Demolition of existing redundant garage building & erection of 1 No. dwelling and associated works (alternative following Y/68/17/PL). This application may affect the setting of listed buildings & may affect the character & appearance of the Main Road/Church Road, Yapton Conservation Area.

Garage Premises Main Road Yapton

Thank you for your internet comments made on 25th April 2019 which has been recorded as **'support'** with the comments as follows:

PROJECT		CLIENT	DATE	DRAWN
Reptune Garage site Main Road YAPTON		P Mountford	Feb 2019	pm
DRAWING	SCALE	REV	DRAWING NO	
Proposed elevations	1:100@A3		1801/06

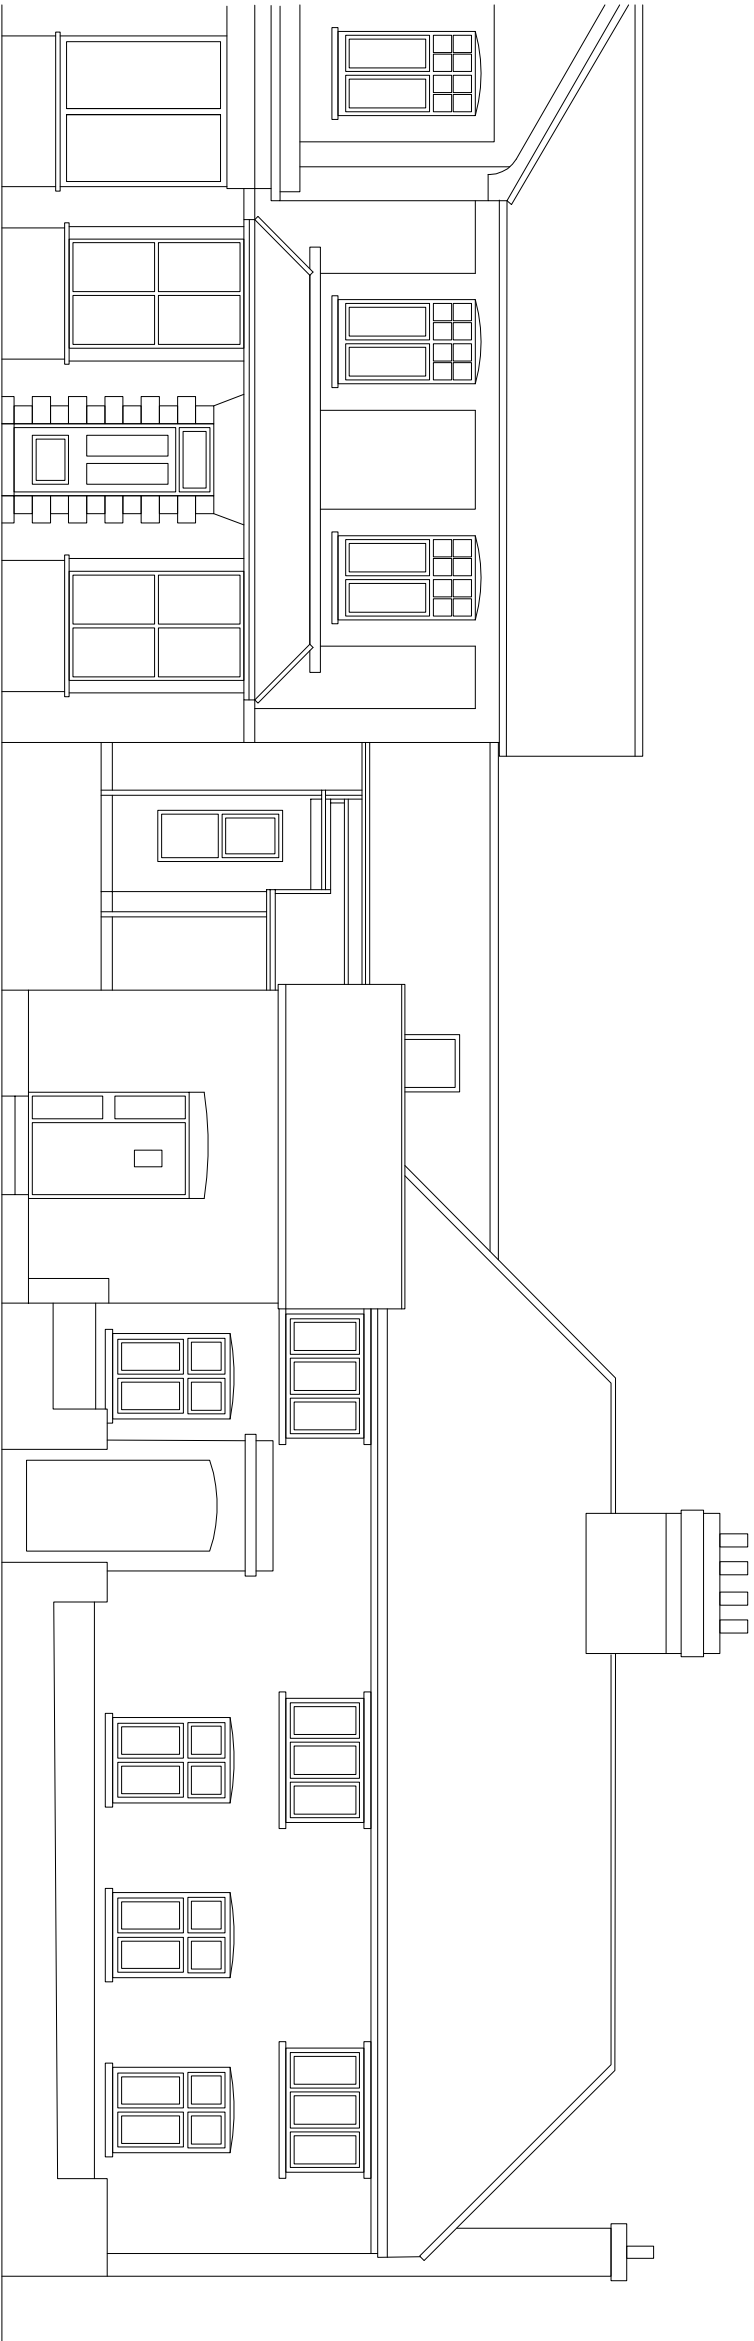
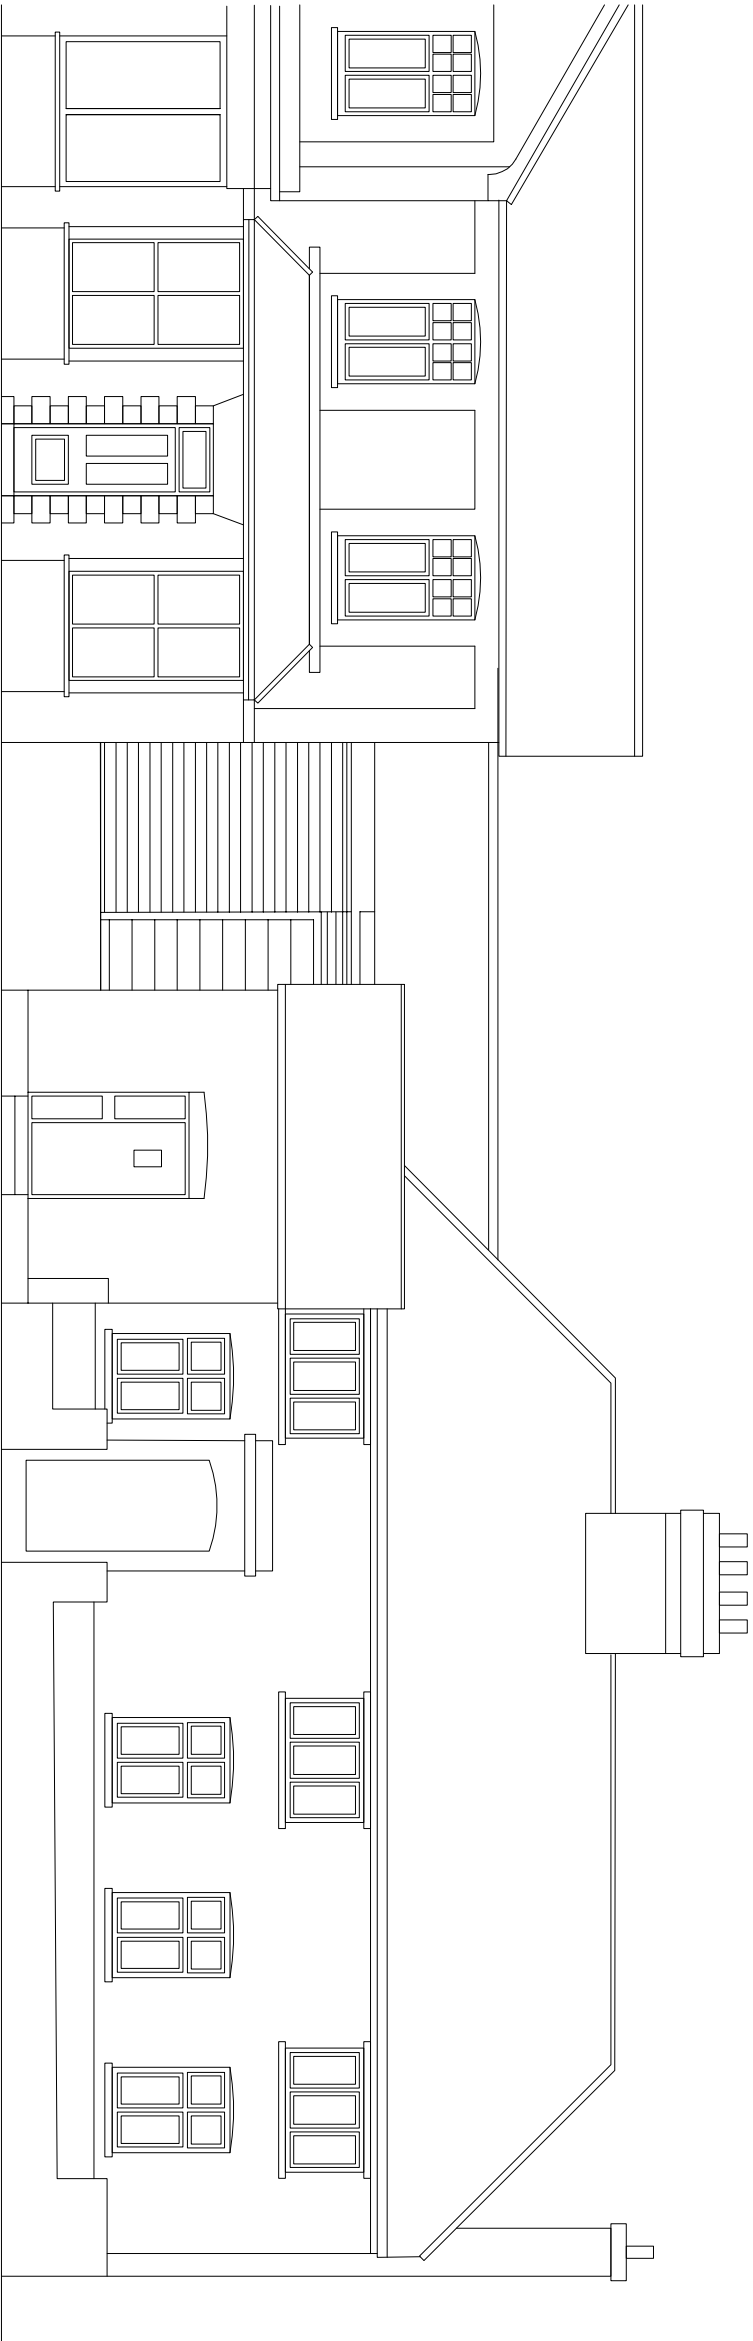
- 6. Roofline not to exceed the existing building's ridge and eaves heights.*
- 7. No balconies, roof terracing or external open areas on the western elevation to ensure that existing residential properties are not overlooked from an elevated open height.*
